December 20, 2023

Attn.: Mr. Brad Walters, Inspection Supervisor
RE: Solace Apartments Filing No. 1 – Pond Certifications

This letter is intended to provide documentation with County Inspection Staff that the Pond facilities in Solace Apartments Filing No. 1 have been constructed within reasonable conformance to the design. The District owned pond facilities for Solace Apartments Filing No. 1 are described by the following:

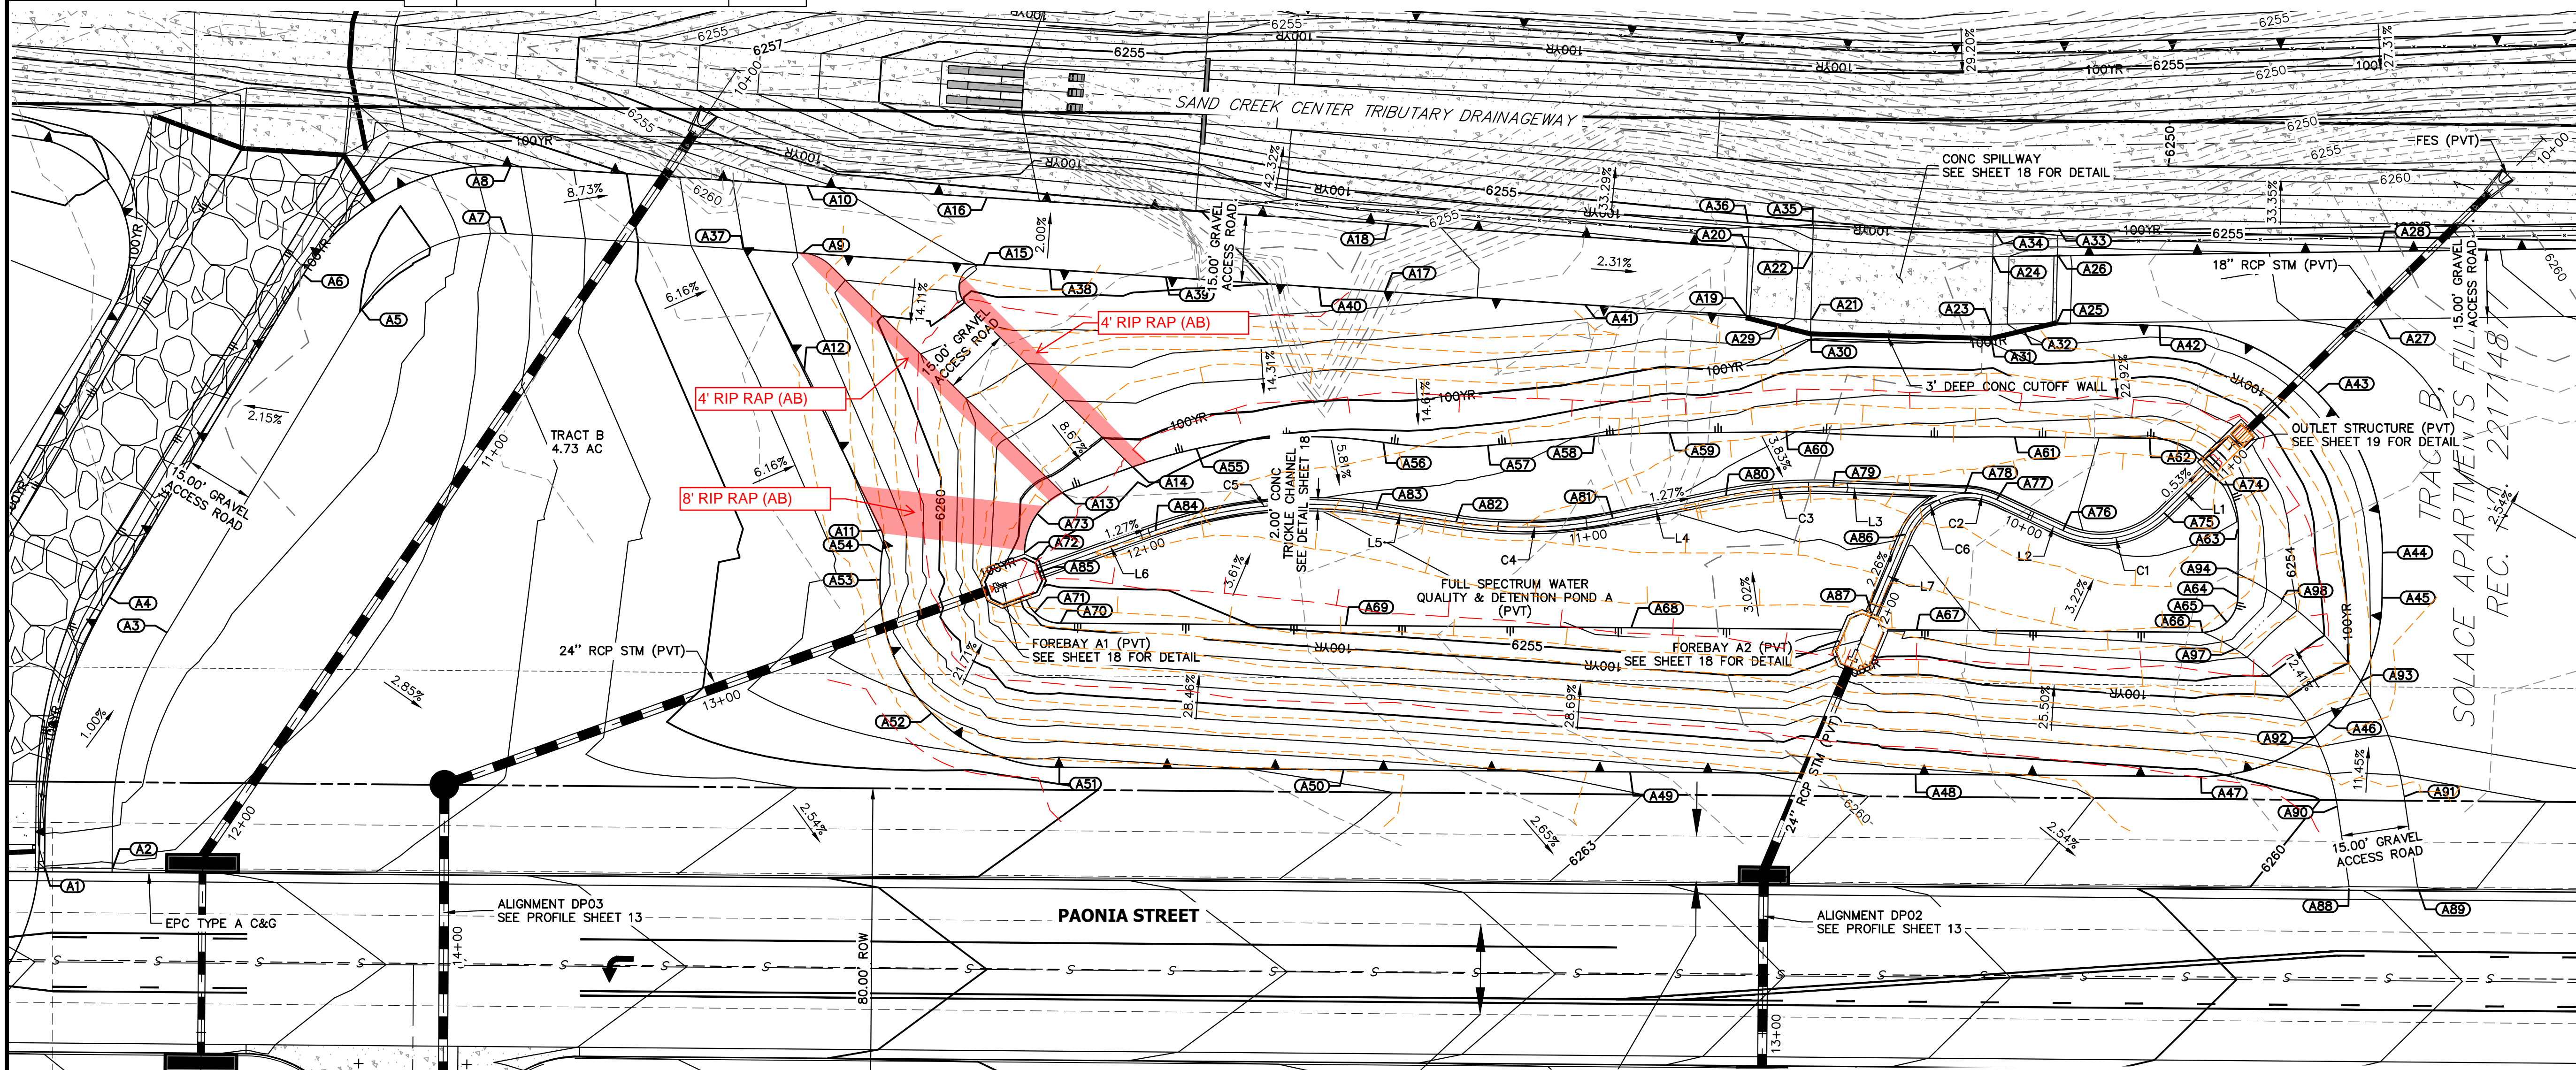
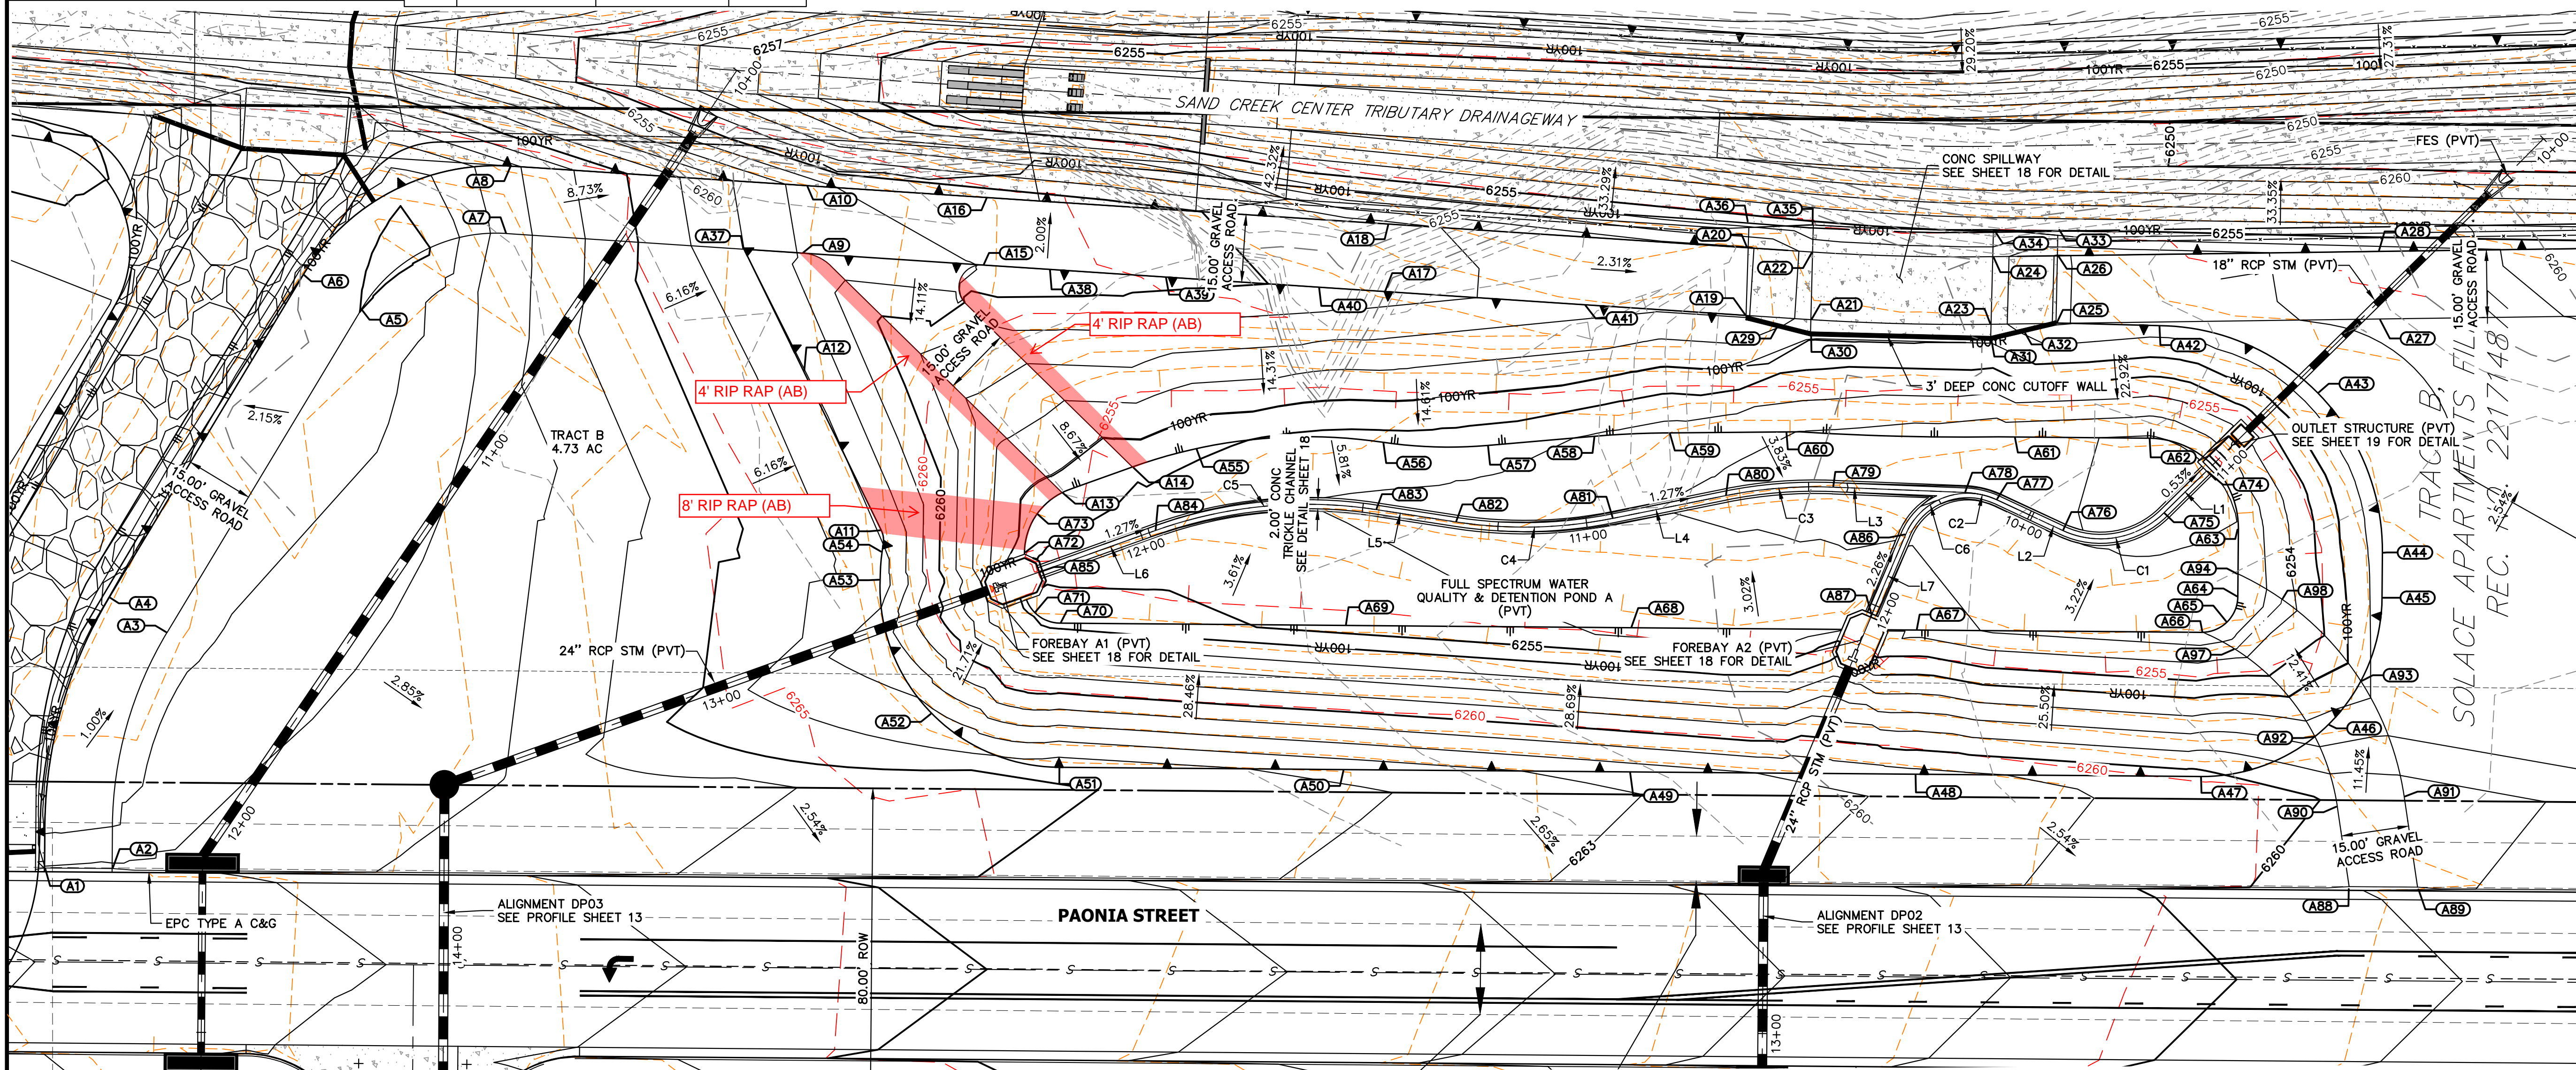
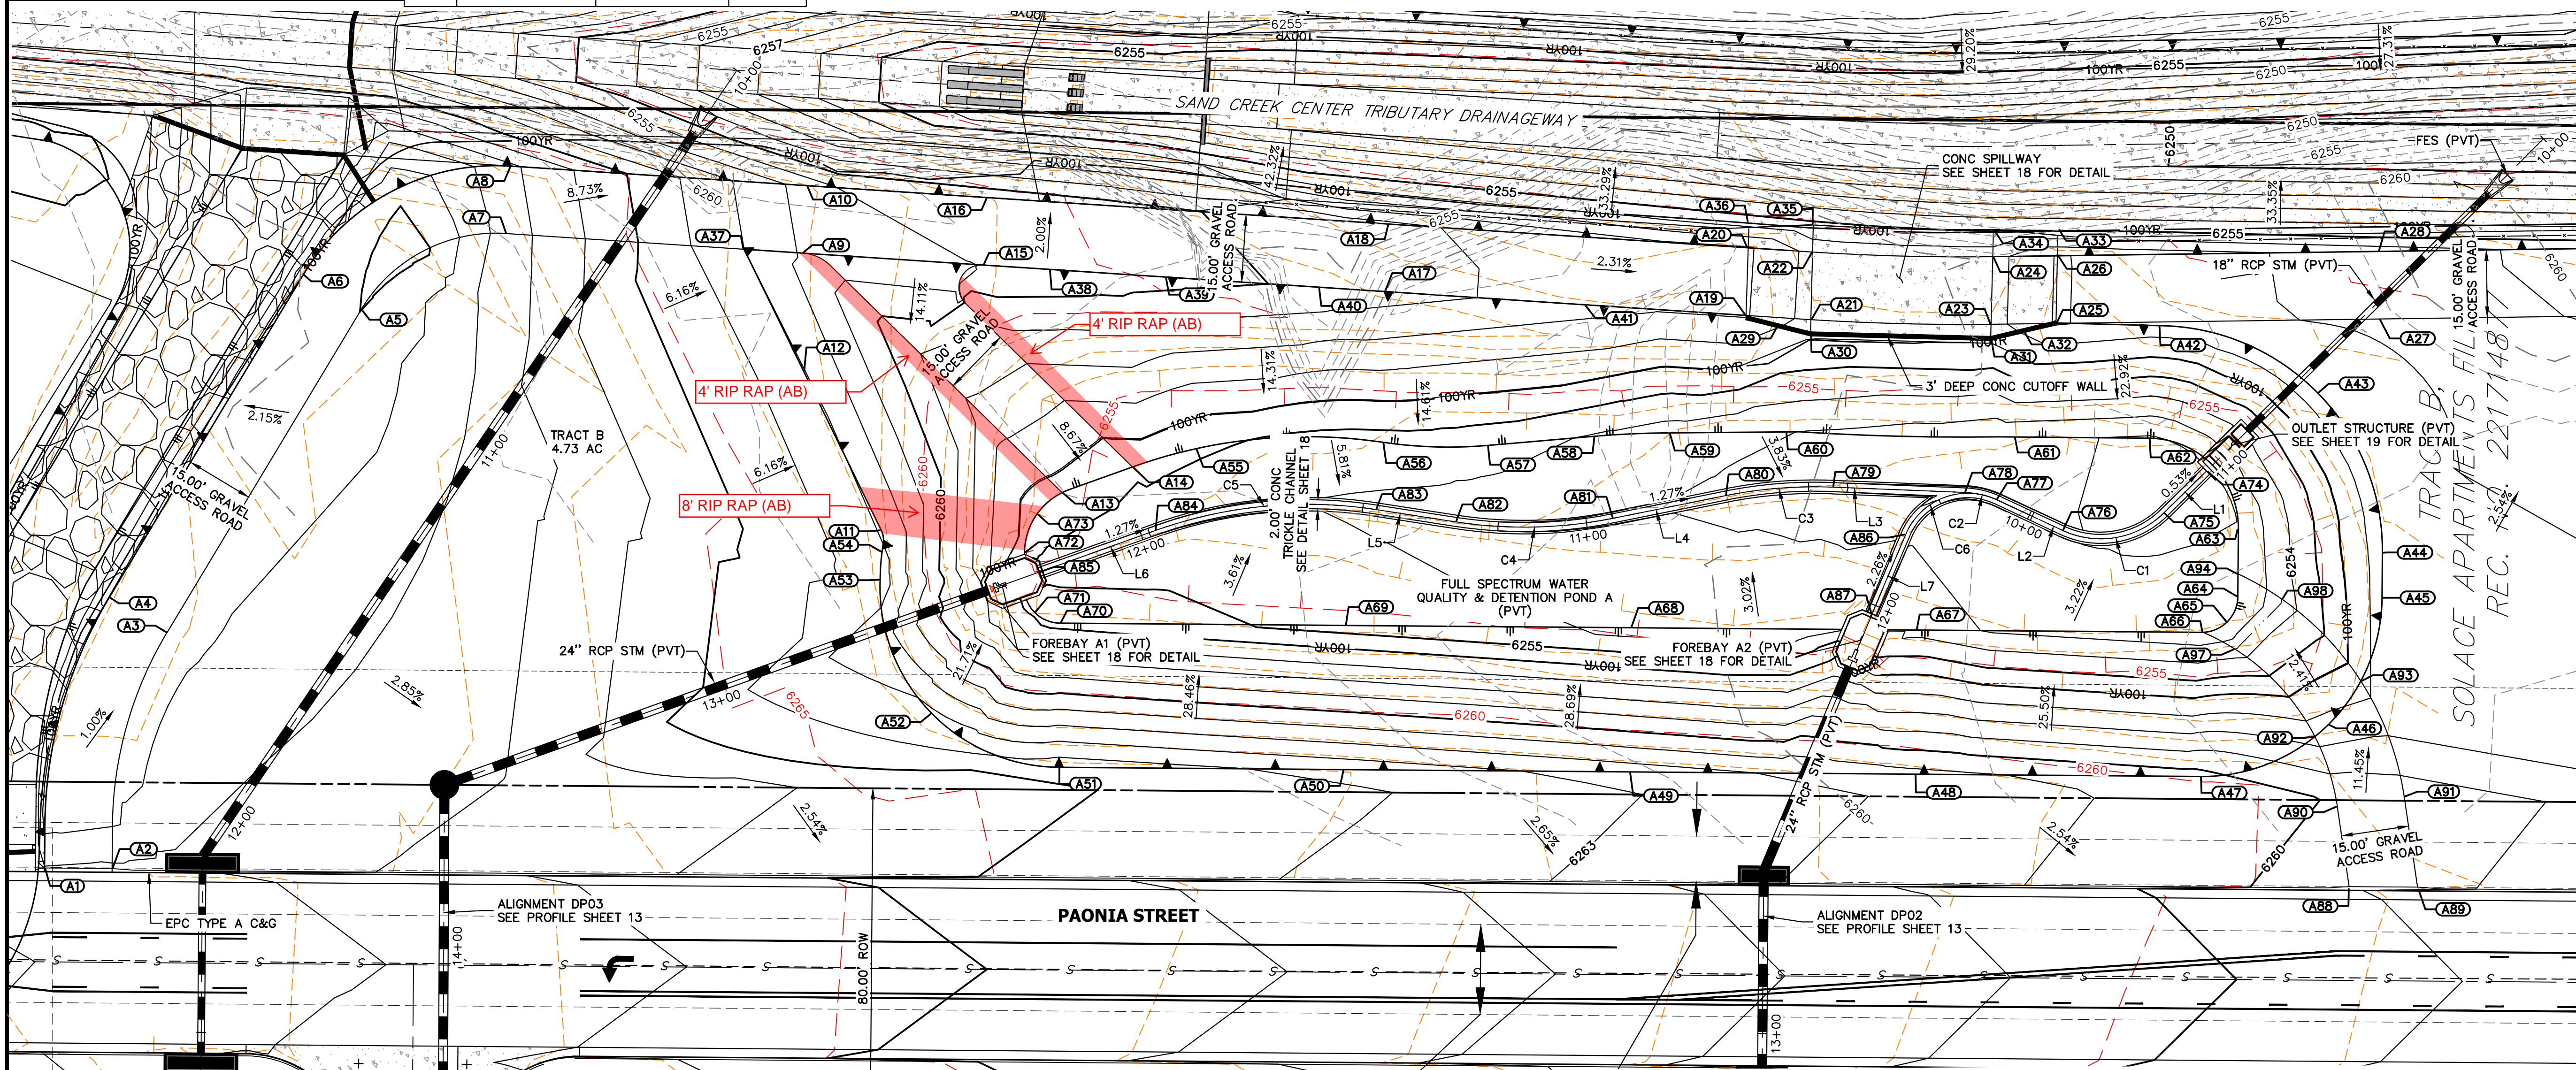
The drain time exceeds the allowable limits for the 2-year and 5-year. The pond must be within allowable ranges for drain time.
